### **Final Report - Corrections Required** **Application No. DEPN-24-0160**

**Description : Multi-family development with 170 rental duplex units on one development lot. Also a request for alternate landscape compliance related to placement of streamside overly and property boundary buffer plantings, and to be allowed to provide 9.4% active open space where 10% is required.**

**Address : 2210 Old Ranch RD Colorado Springs CO 80920**

**Document Filename : Cottages at Kettle Creek - Traffic Impact Study\_Oct2024.pdf**

## SITE PLAN

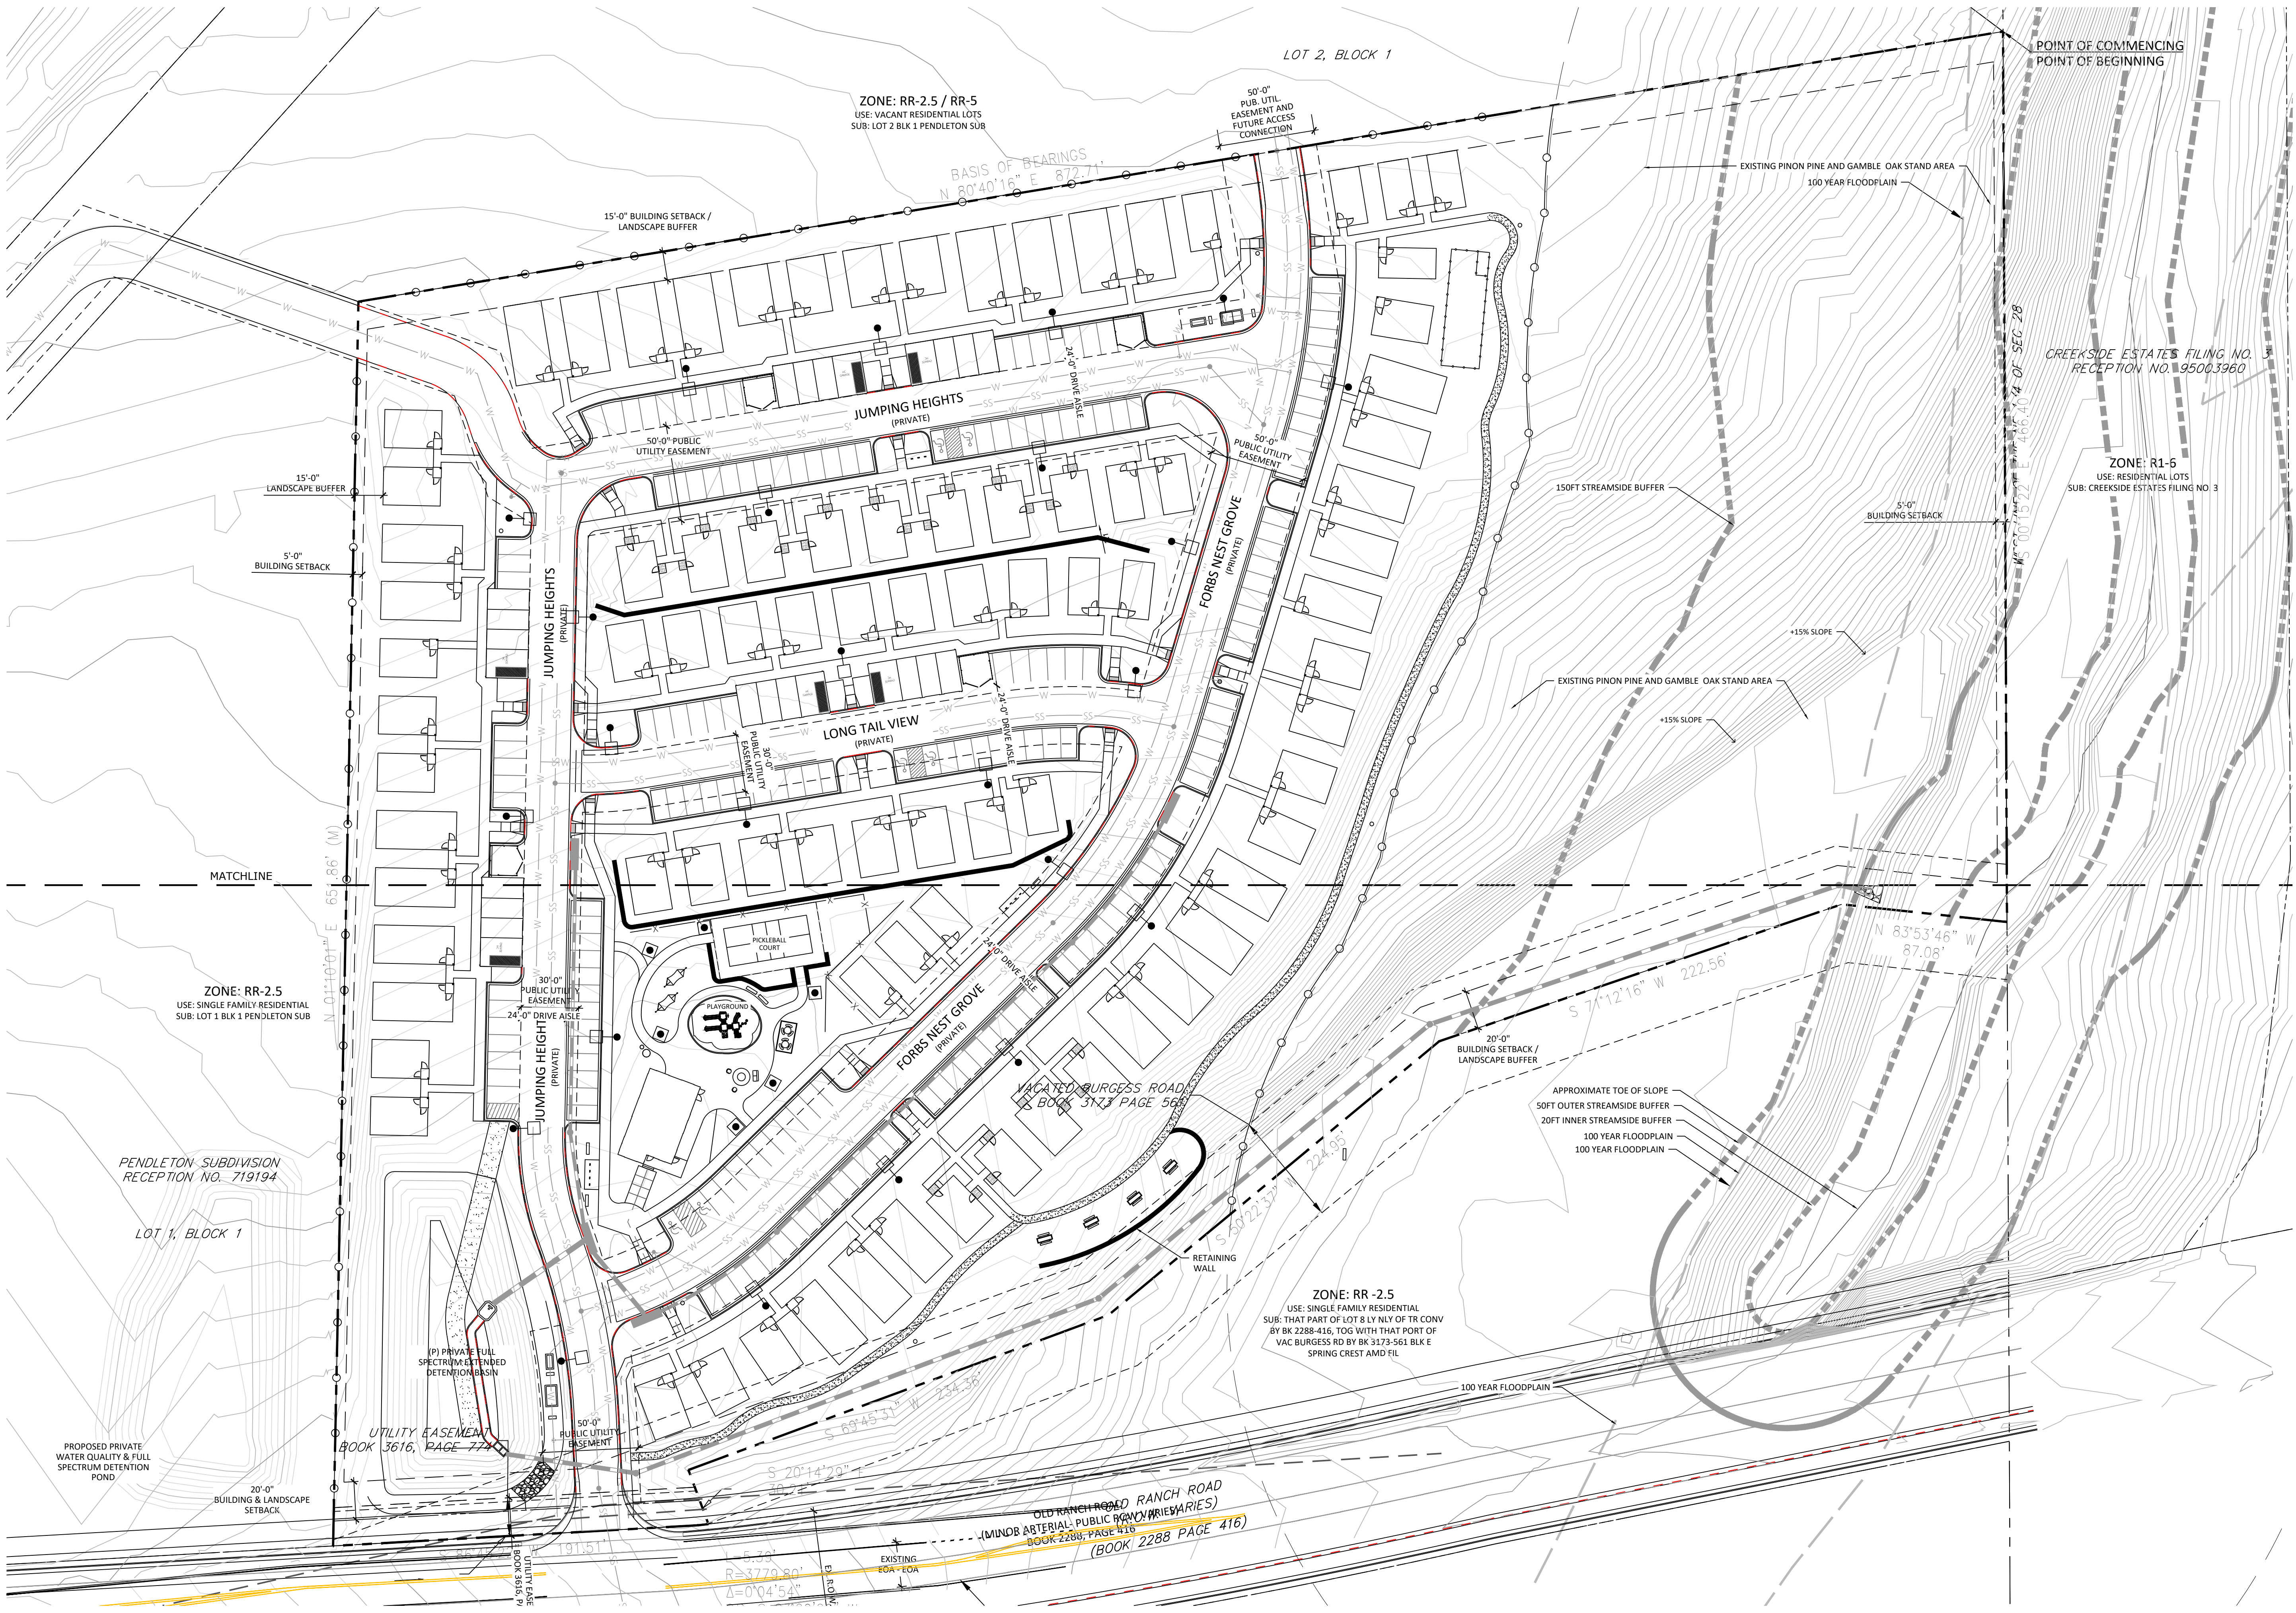
Comment ID	Reviewer : Department	Review Comments
		<p>4. I am only seeing 6 garages not 7. Please label the 7th.  5. Regarding the shaded seating area, how is it shaded? Gazebo, canopy?  6. Each duplex structure will be assigned a single address with unit numbers 101 &amp; 201. Contact me when you are ready to have the area addressed.</p> <p>Amy Vanderbeek  Enumerations Plans Examiner  Pikes Peak Regional Building Department  O: 719-327-2930 E: Amy@pprbd.org</p>
